**WARRIEWOOD: 14 – 18 BOONDAH ROAD, WARRIEWOOD (LOT 20, DP 1080979)
S75W TO PROJECT APPROVAL MP10_0177**

Pursuant to Section 75W(1)(a) of the Environmental Planning and Assessment Act, 1979, a "Modification of Approval" is sought to amend Condition B13 and incorporate studies into Buildings A, B and C of the Project Approval (MP10_0177), as granted by the Planning and Assessment Commission on the 18th January 2011.

BUILDING A PLANS & ELEVATIONS
SCALE 1:200

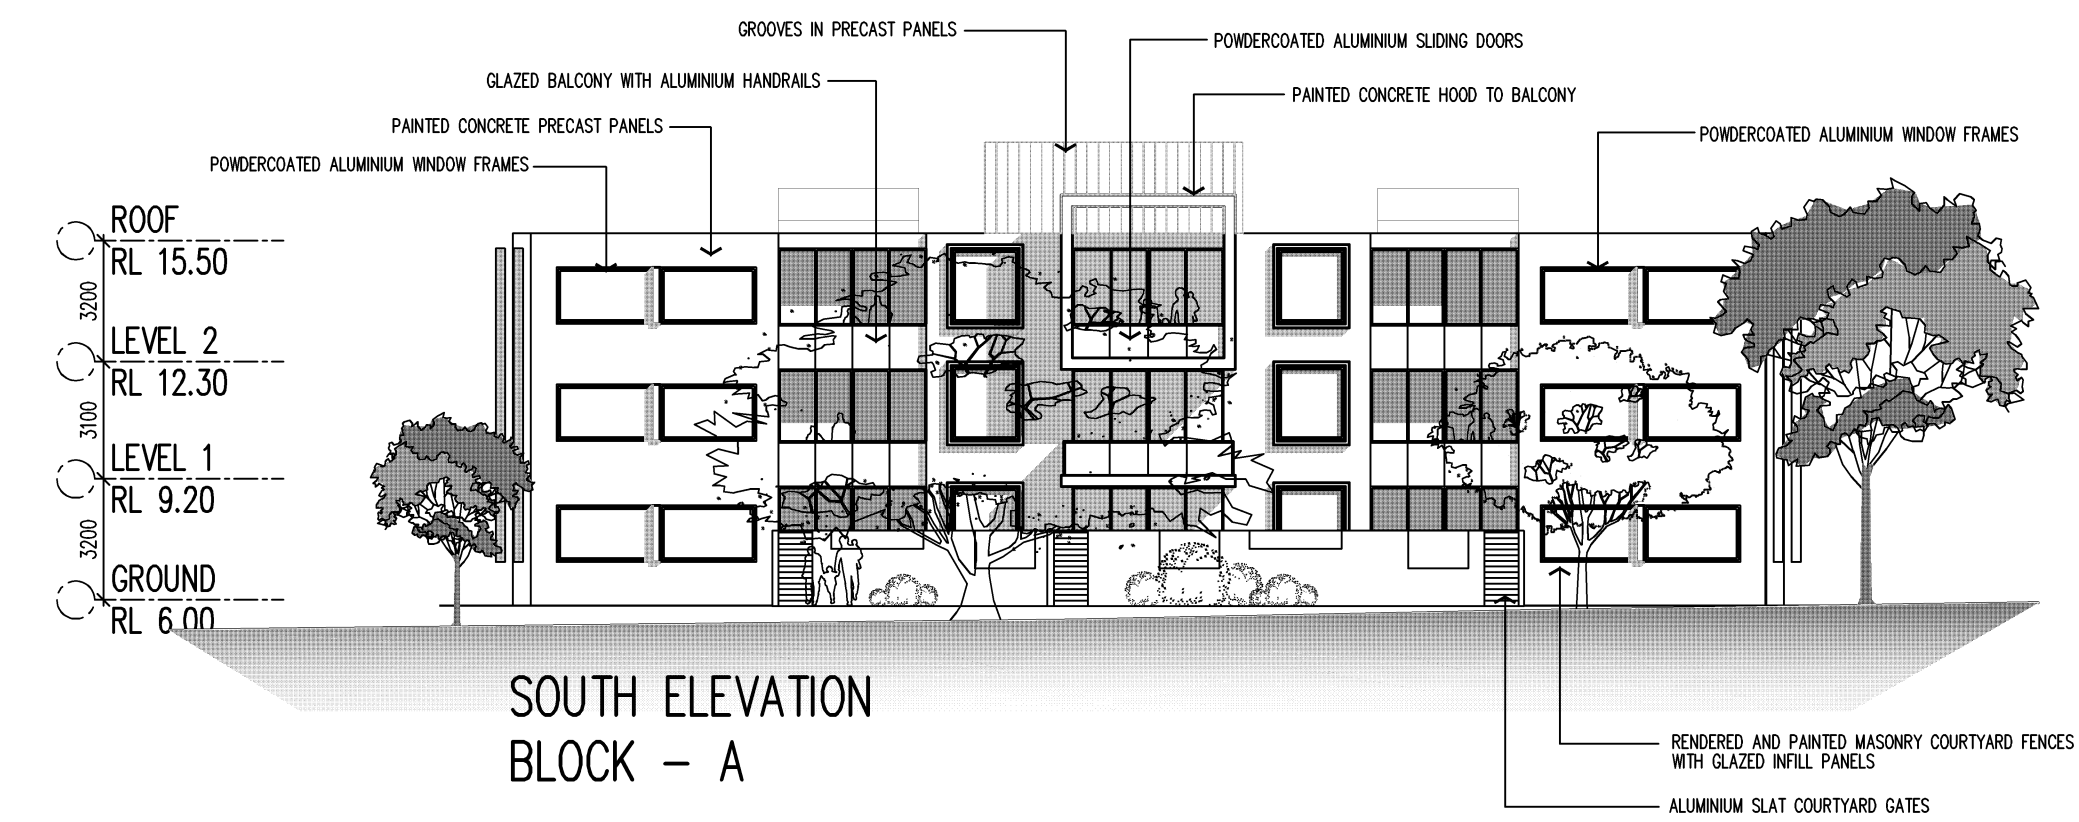
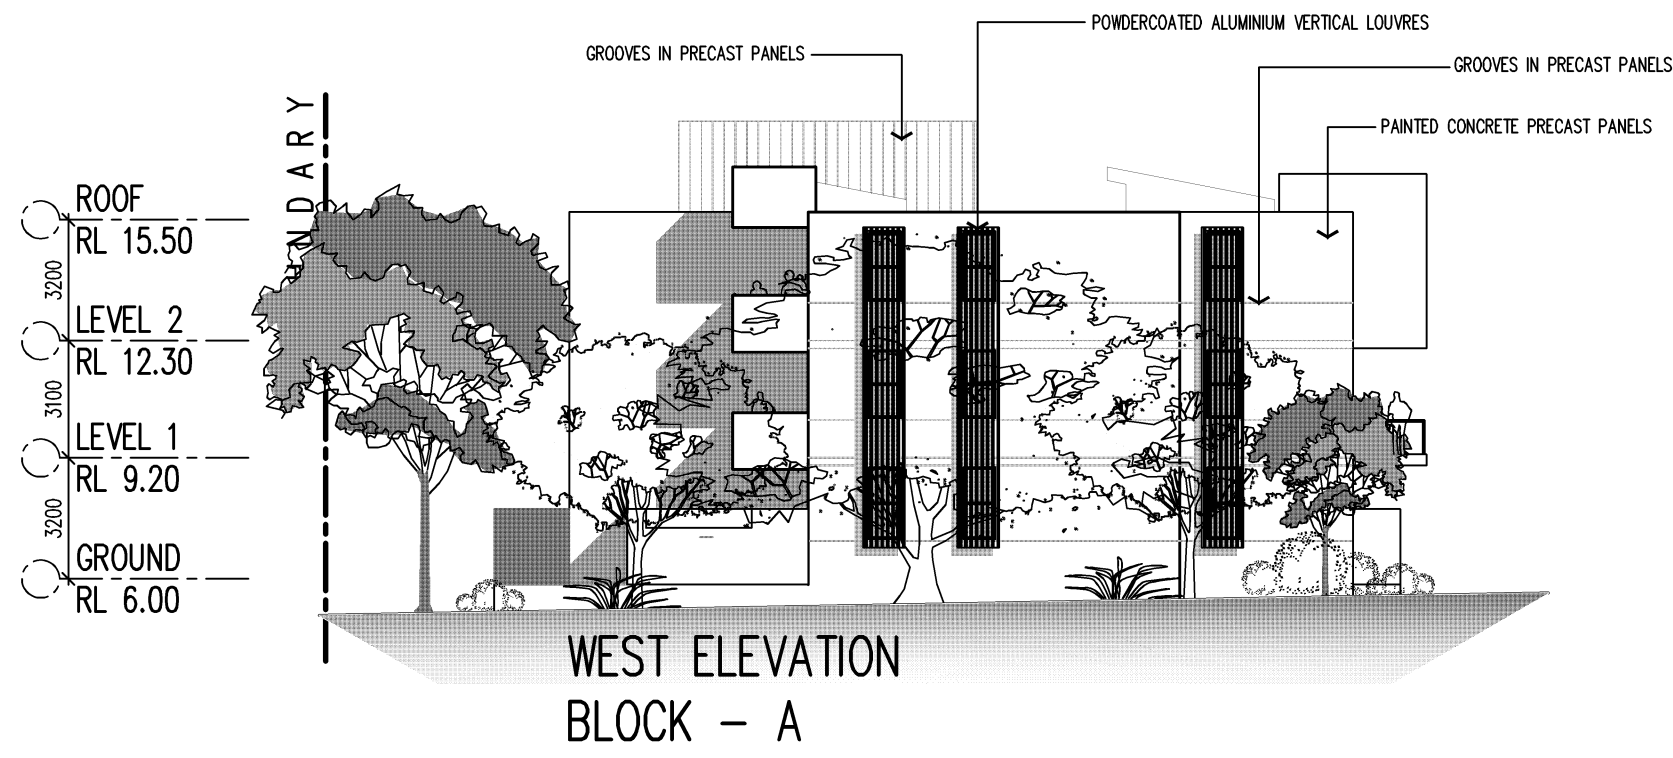
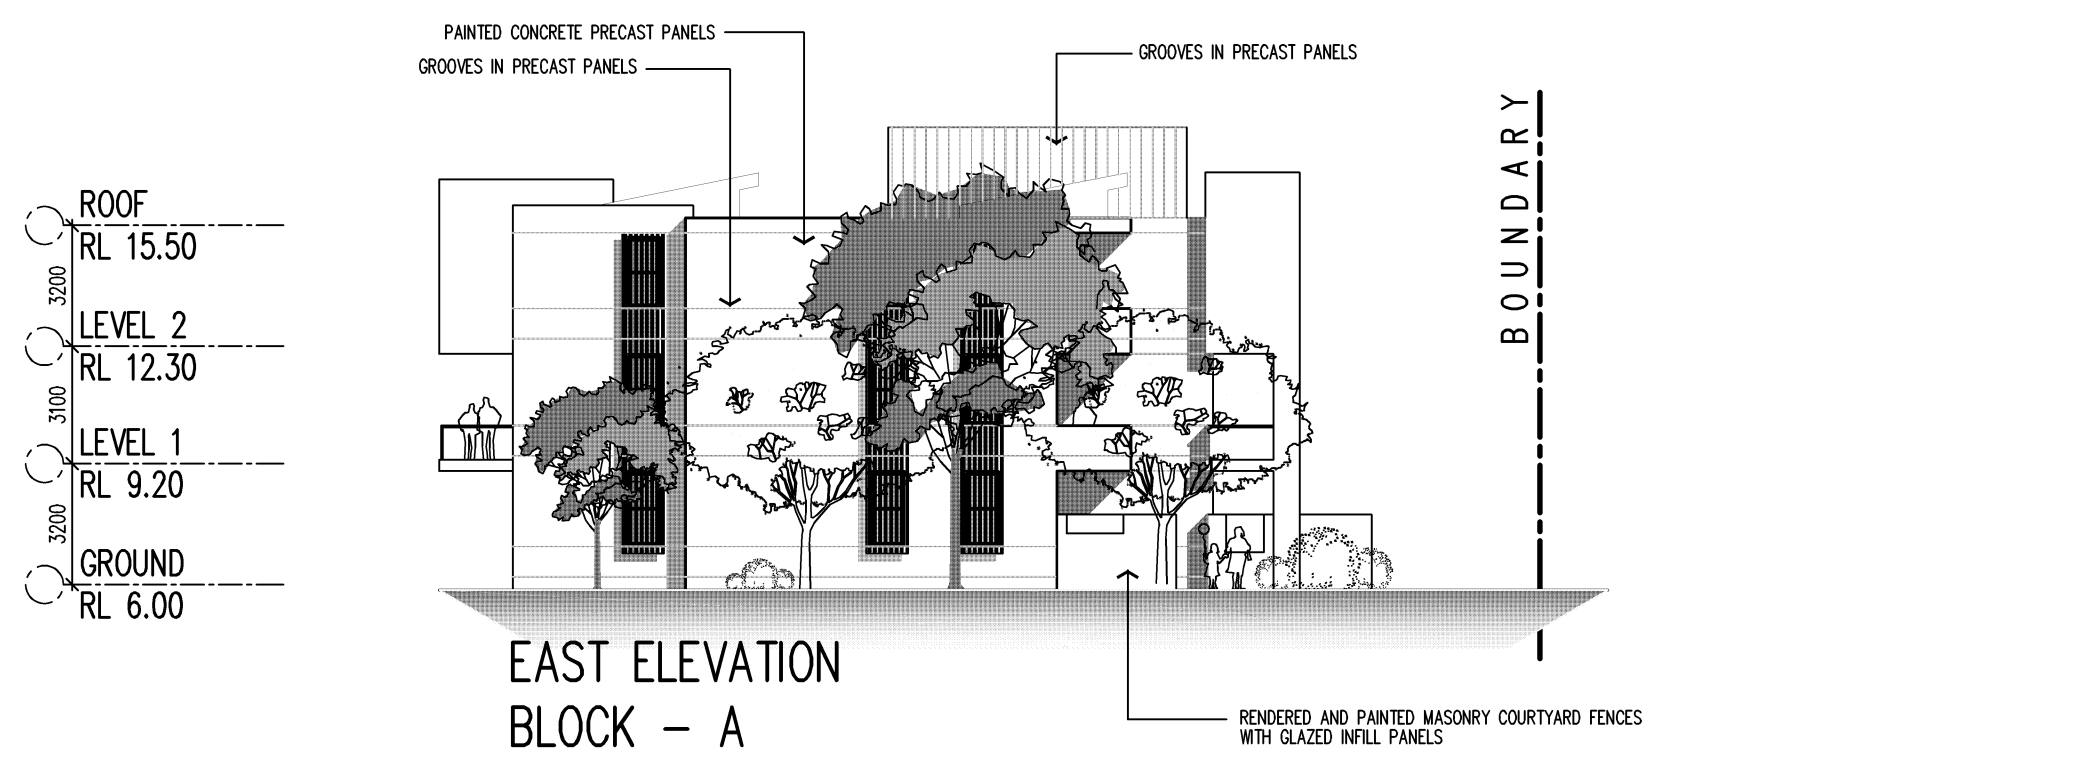
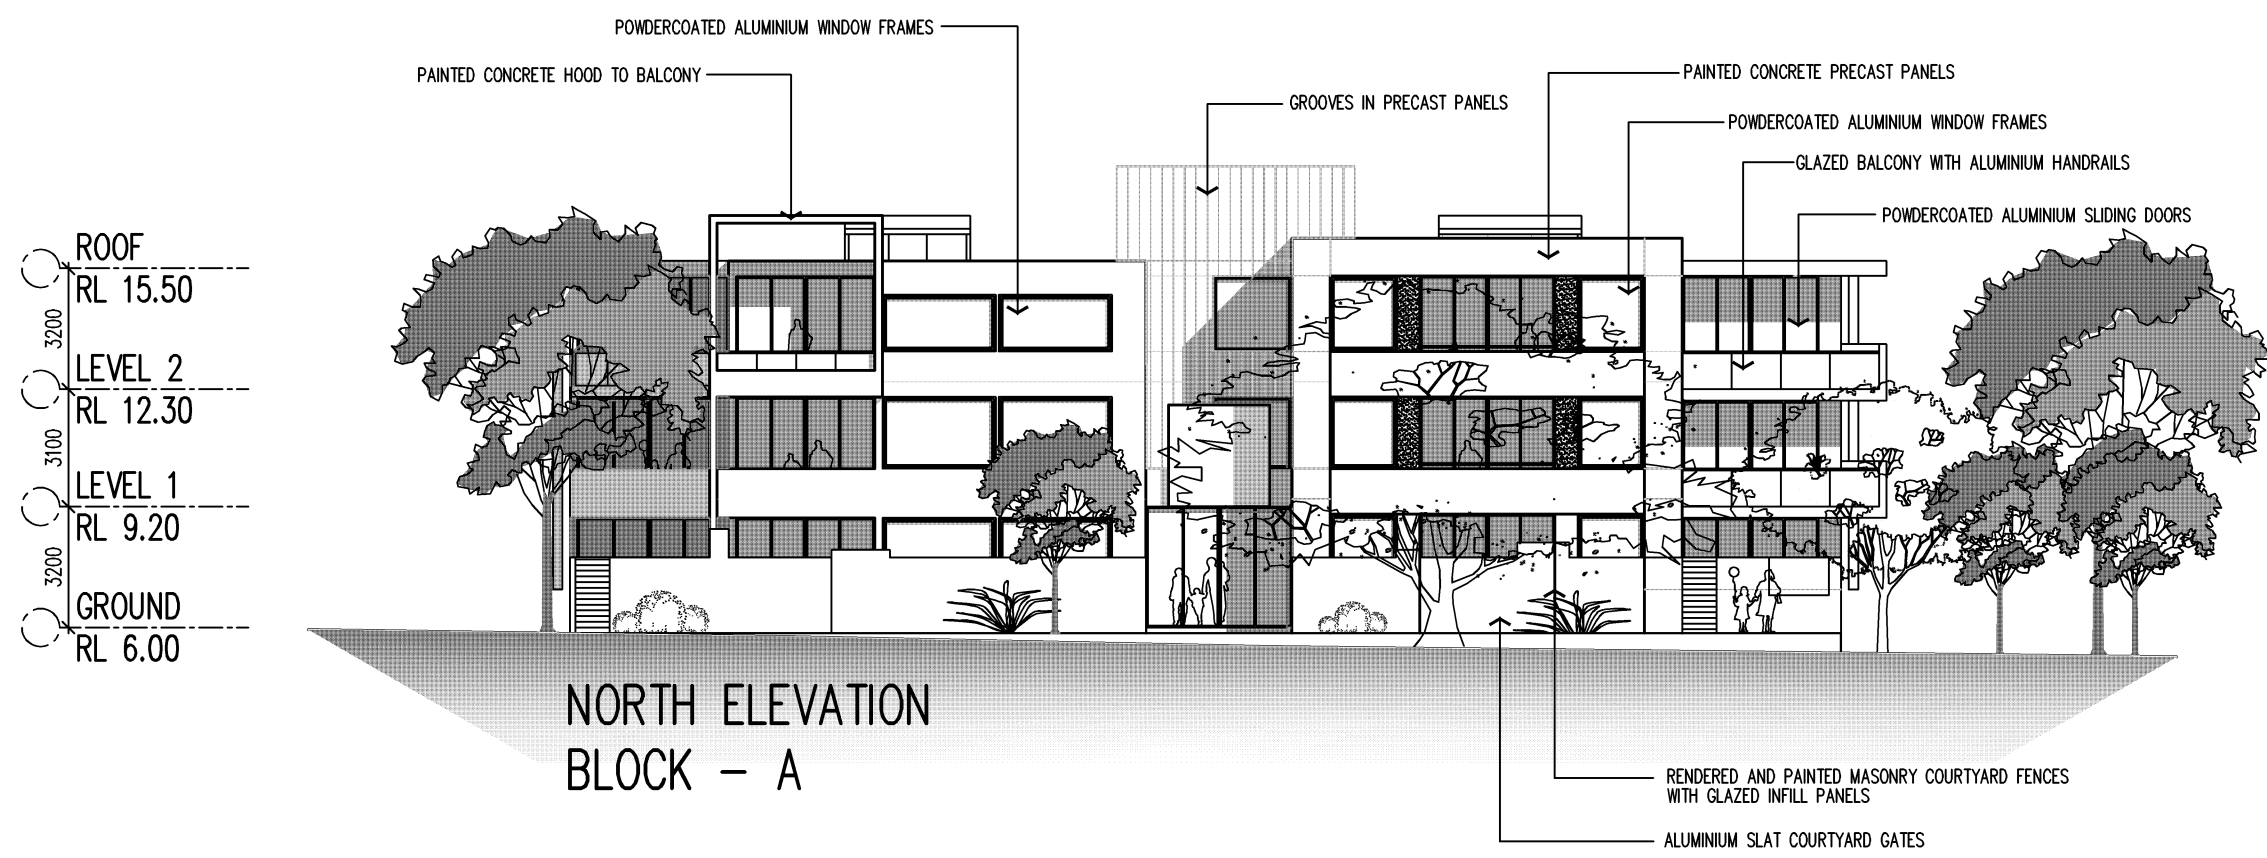
1. Reduce 1 level of basement car parking with associated podium adjustments; and
2. Amend the floor layout of units in Buildings A, B and C to include a study.

Studies

The introduction of studies into units within Buildings A, B and C is responding to market demand. The standard family use of computers, large television or having an exercise machine in another part of their apartment is now entrenched with the daily lives of people. Therefore a study room will serve as a purpose for enabling a household to use the study for the additional living space that is sought to be separated from the other rooms in the apartment.
